CITY OF ALBUQUERQUE

April 7, 2015

**Re: Toyota Temporary Parking Lot, Grading and Drainage Plan
Engineer's Stamp Date 2-24-15 (C18D083)**

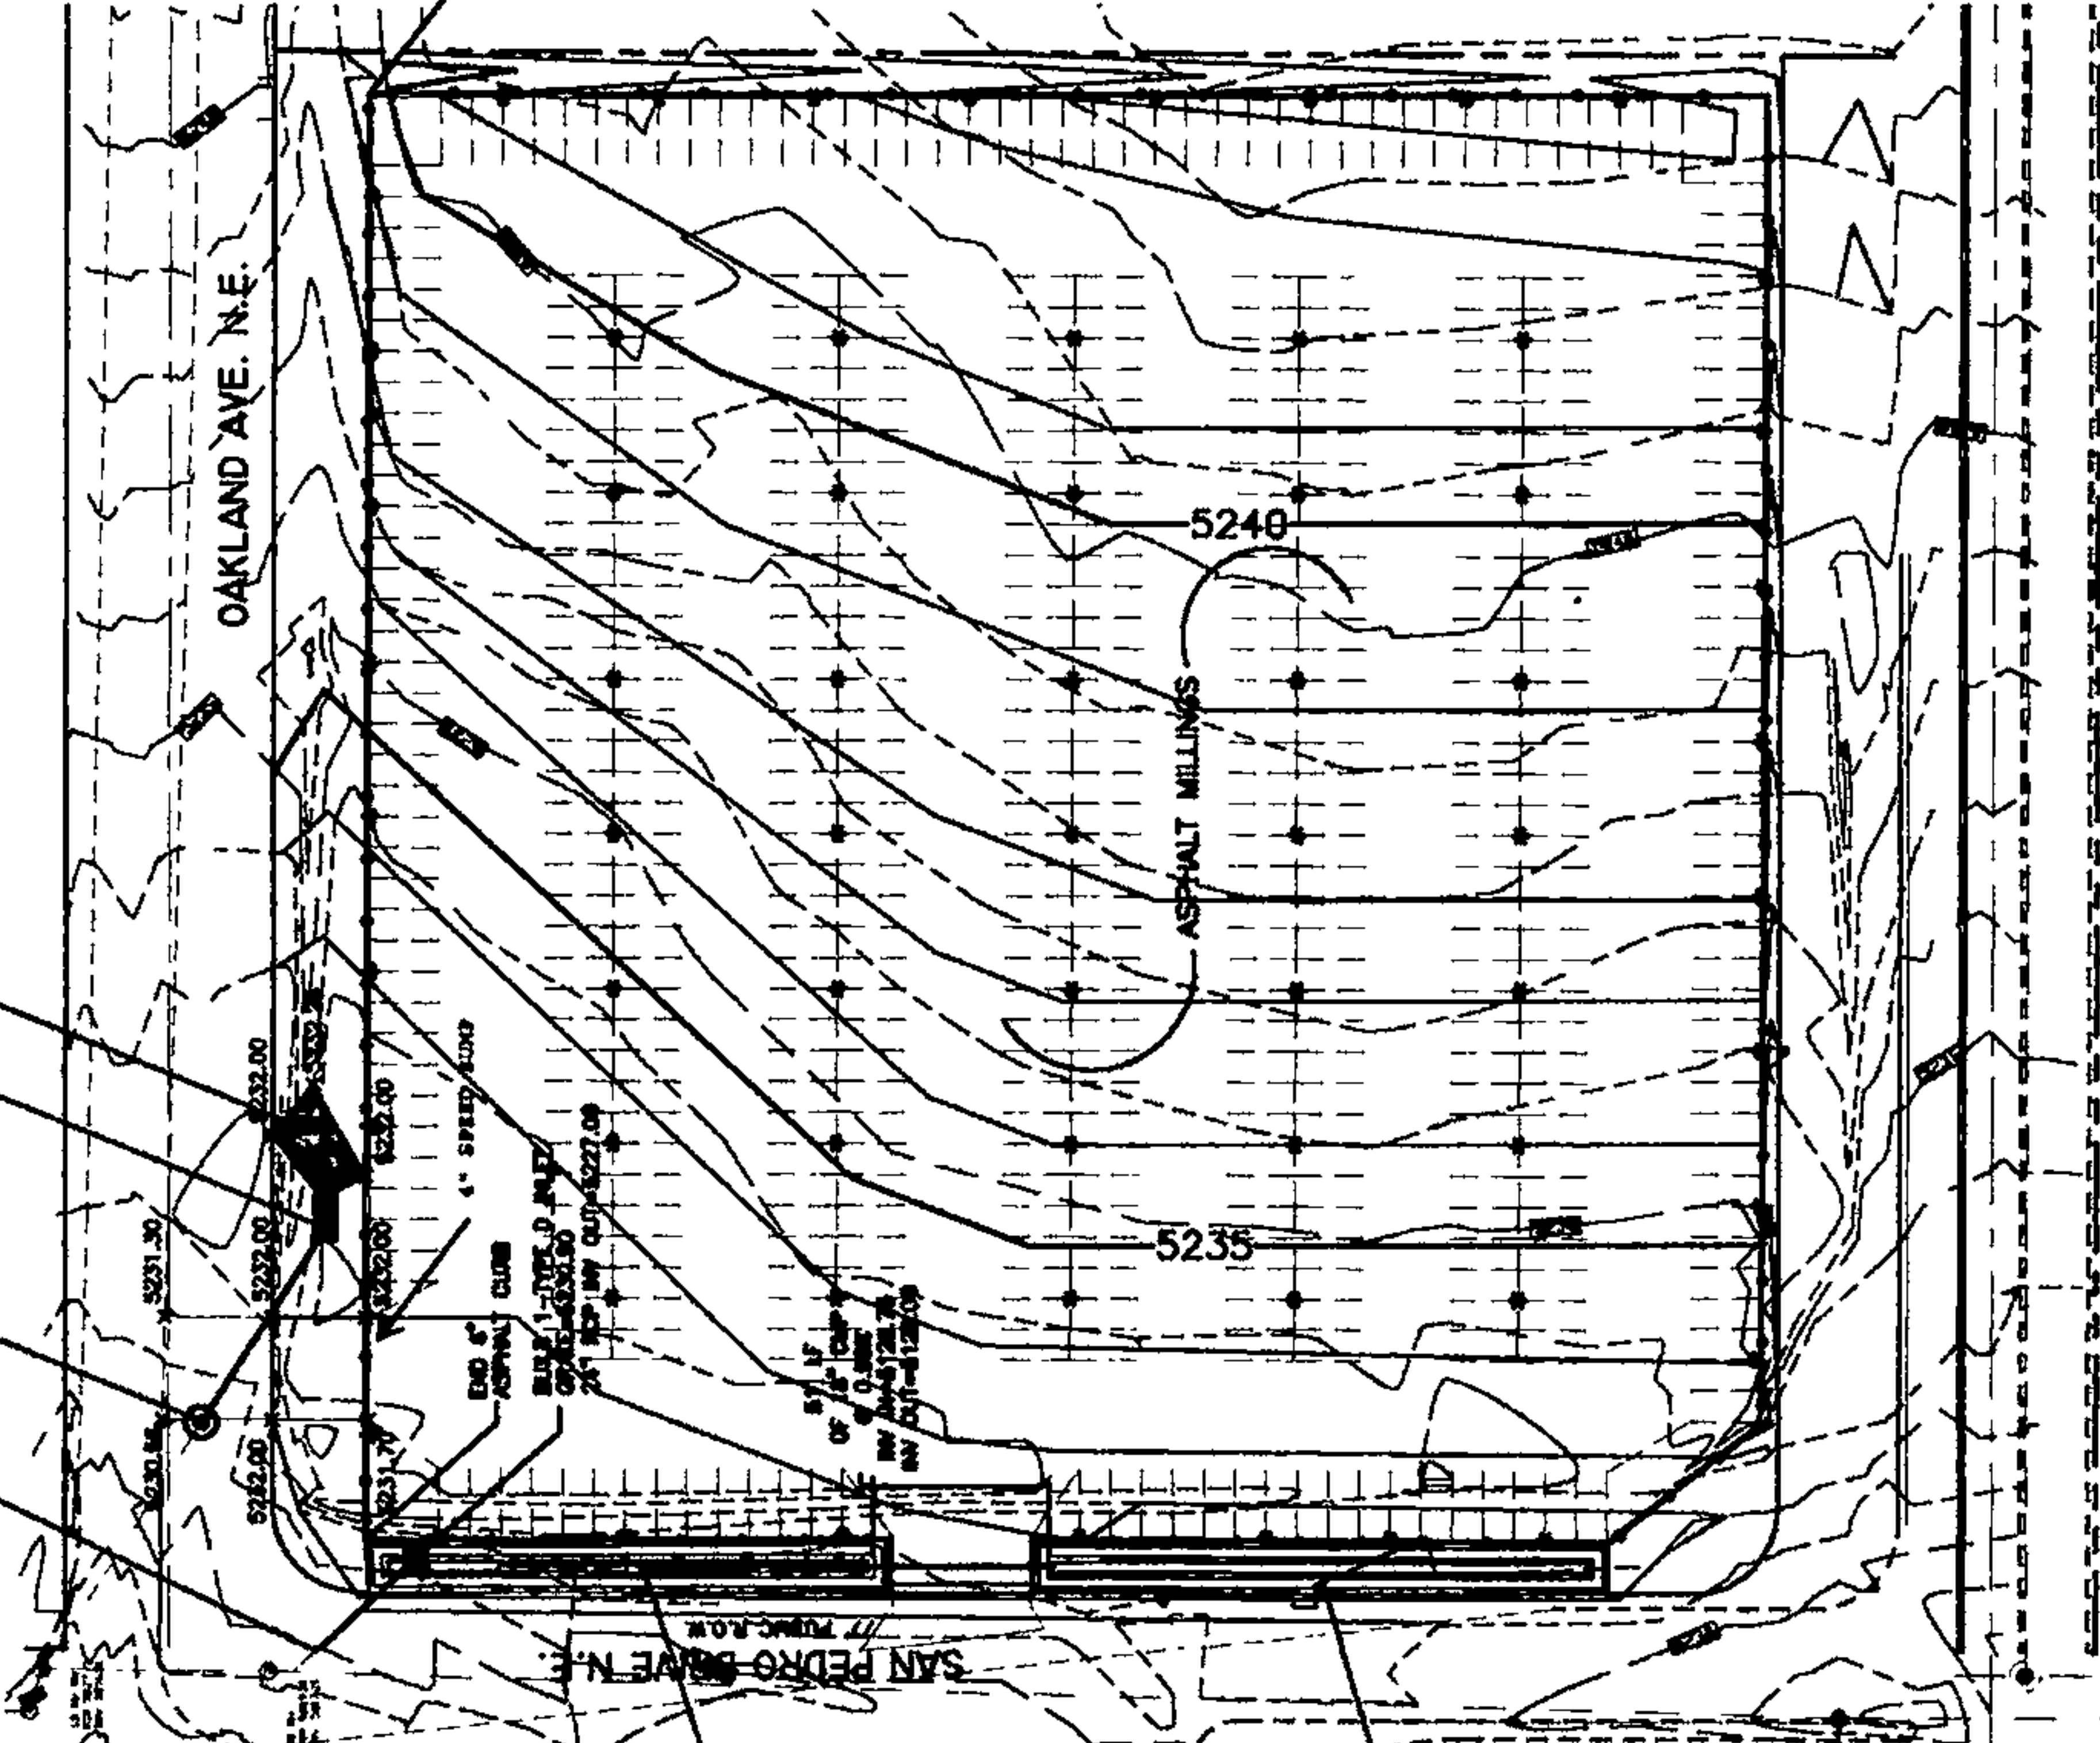
1. It appears a large portion of Onsite Basin A will drain to Oakland Ave ROW rather than to the northern onsite pond. Since the millings have already been laid, an asphalt curb could be constructed form the west edge of the millings east to the proposed 35 contour. Millings or similar should be laid where these concentrated flows will enter the pond to prevent erosion.
2. The work in the ROW will be built per the Work Order process, including the asphalt apron in Oakland Ave. Add a note to the existing build notes, that these times will be built per Work Order.
